The Secretary
NSW Department of Planning, Industry and Environment

20 November 2021

I refer to the Department's below email of 18 November 2021 regarding the Environmental Impact Statement (EIS) for State Significant Development SSD-21190804 Jalco Manufacturing Facility for Fit-out and operation of warehouse 1 of Lot 201 in the ESR Horsley Logistics Park for Jalco Home Care Manufacturing Facility producing, storage, and distribution of household cleaning and disinfection products' at 6 Johnston Crescent, Horsley Park (Lot 201 DP 1244593) in the Fairfield City Council Local Government Area (LGA). Submissions need to be made to the Department by 16 December 2021.

1 Site Facilities Plan (Lot 201)
MS-A010 1:500 @B1

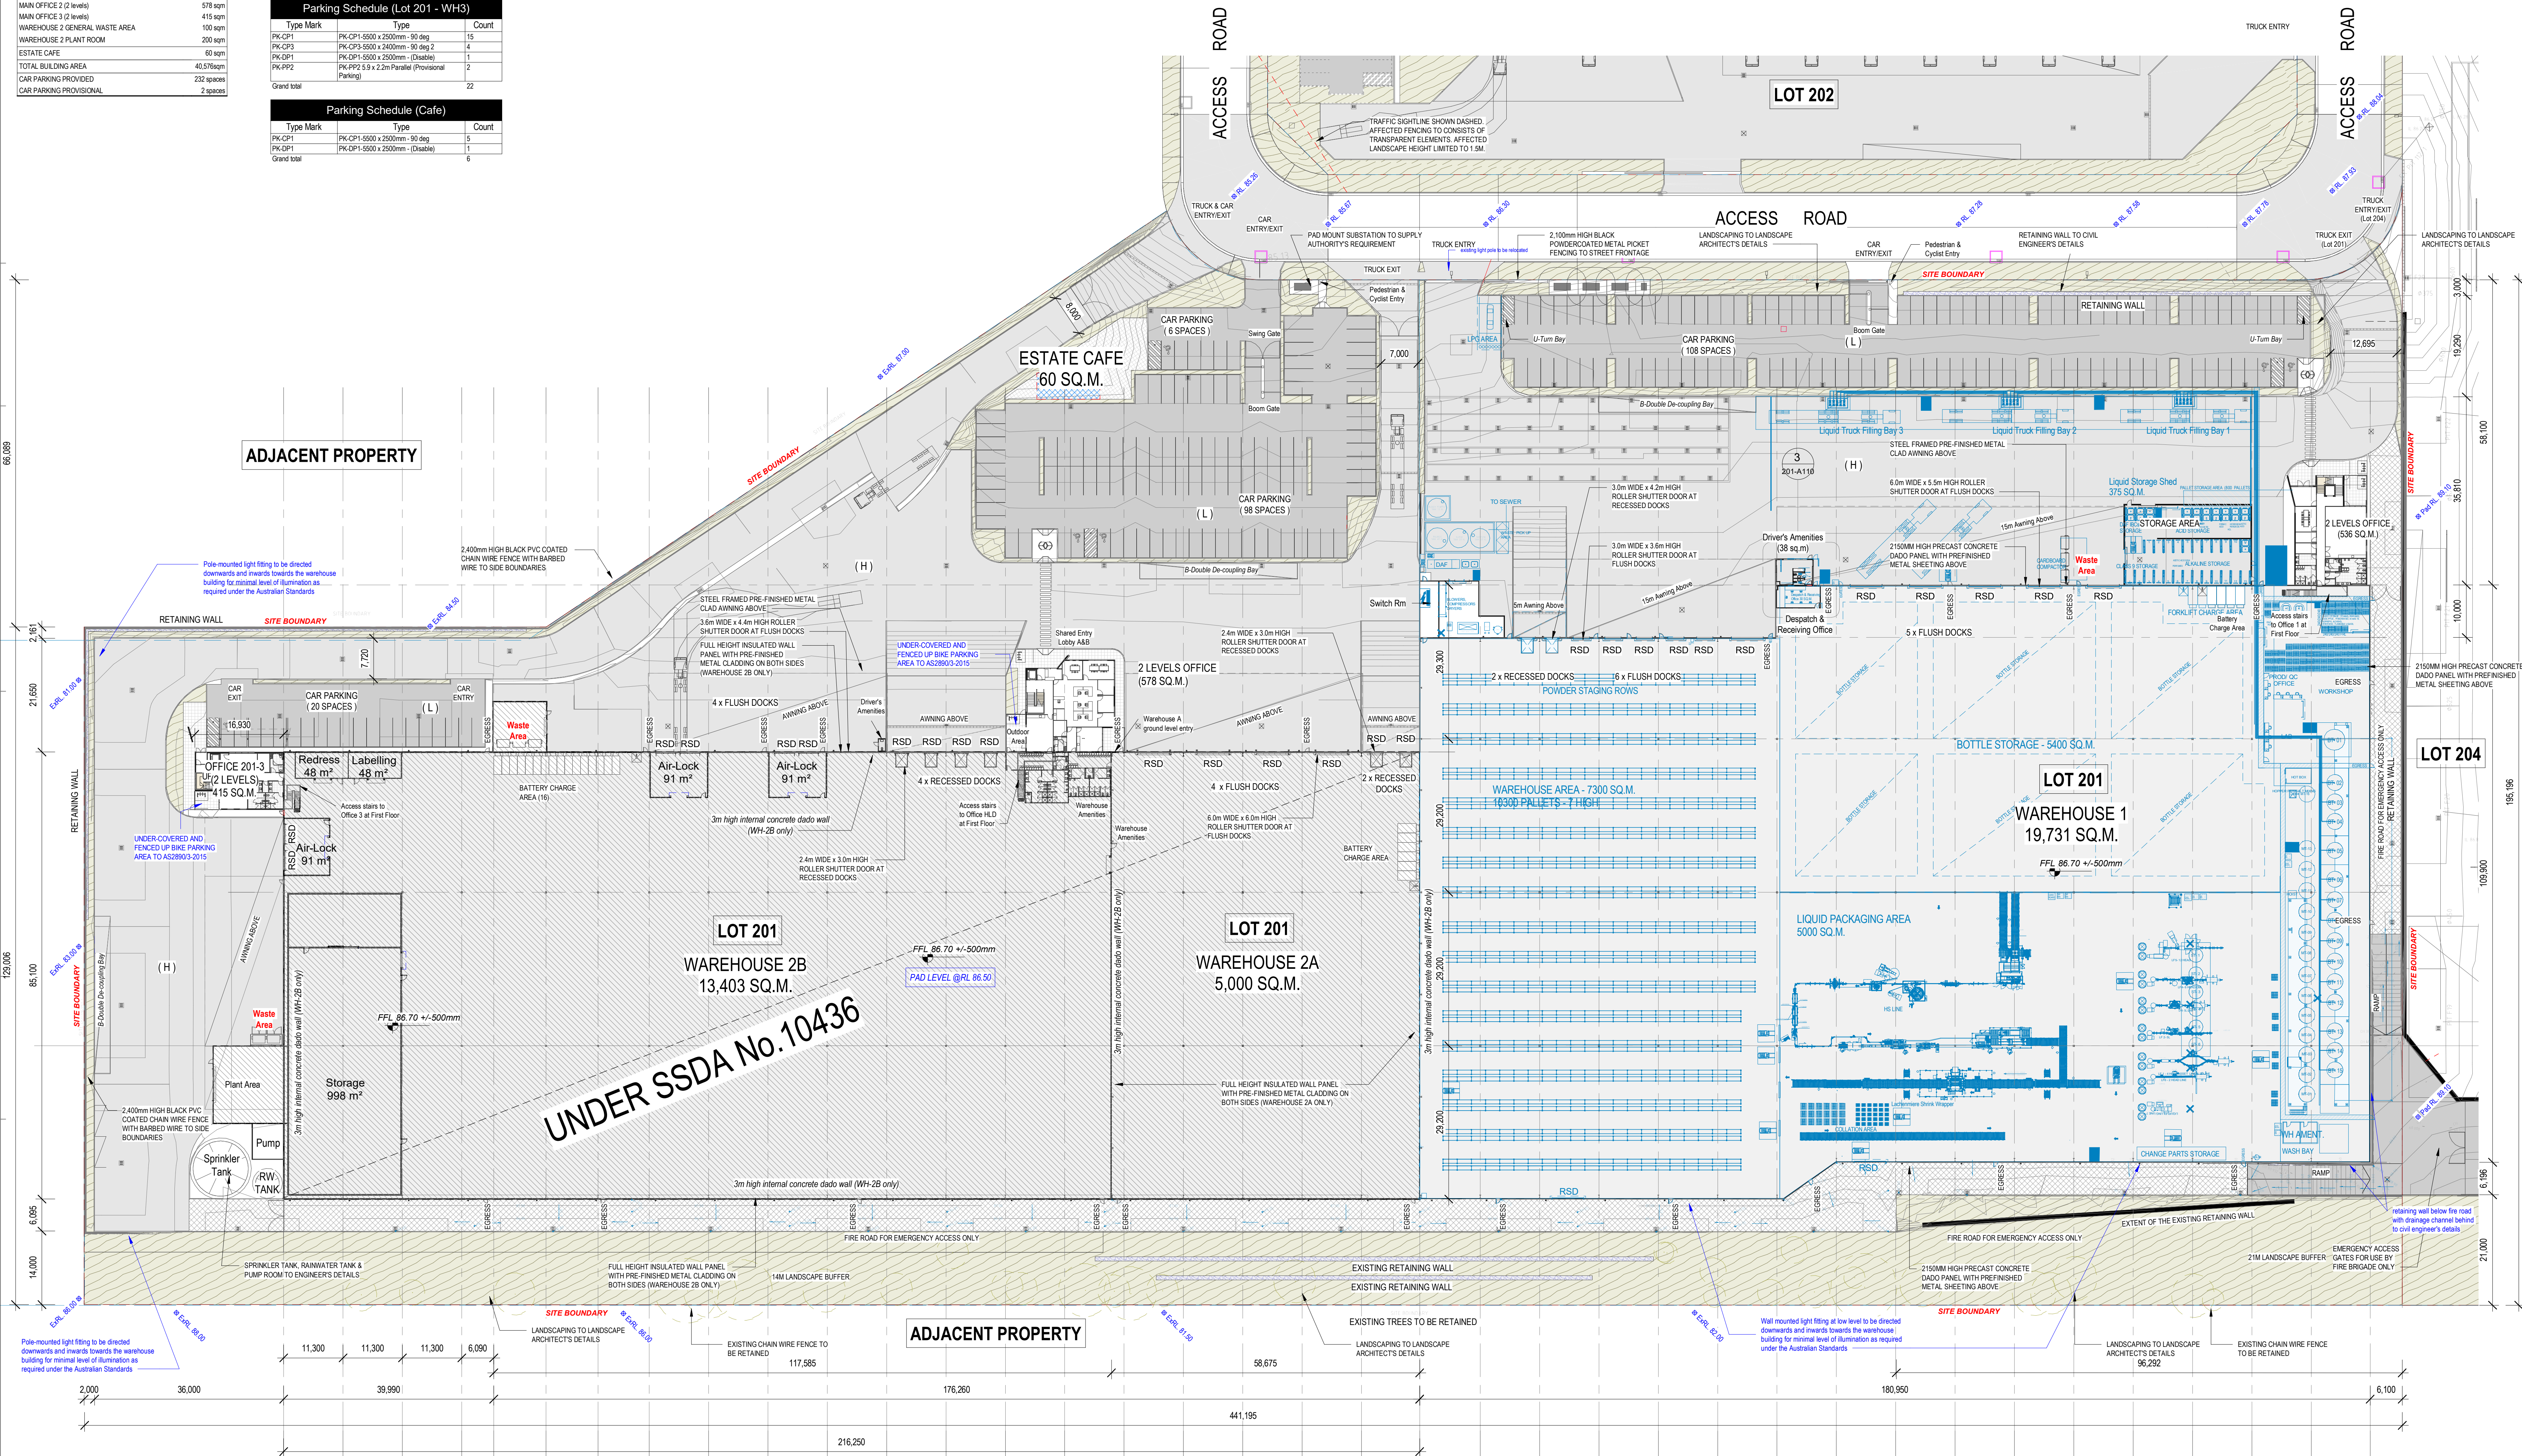
As such it is unclear as to how the other reports provided with the EIS have taken into consideration the electricity infrastructure required to facilitate the proposed development. However as shown in the following extract of the Lot 201 Site & Facility Plan shows the provision for 'Pad Mount Substation to Supply Authority's Requirement'.

Generally it is the Level 3 Accredited Service Provider's (ASP) responsibility (engaged by the developer) to make sure that the substation location and design complies with Endeavour Energy's standards the suitability of access, safety clearances, fire ratings, flooding etc.

From Endeavour Energy's perspective the fact that provision is being made for a padmount substation is a positive. Endeavour Energy's general requirements is for a padmount substation to be at ground level and have direct access from a public street (unless provided with appropriate easements for the associated underground cables and right of access).
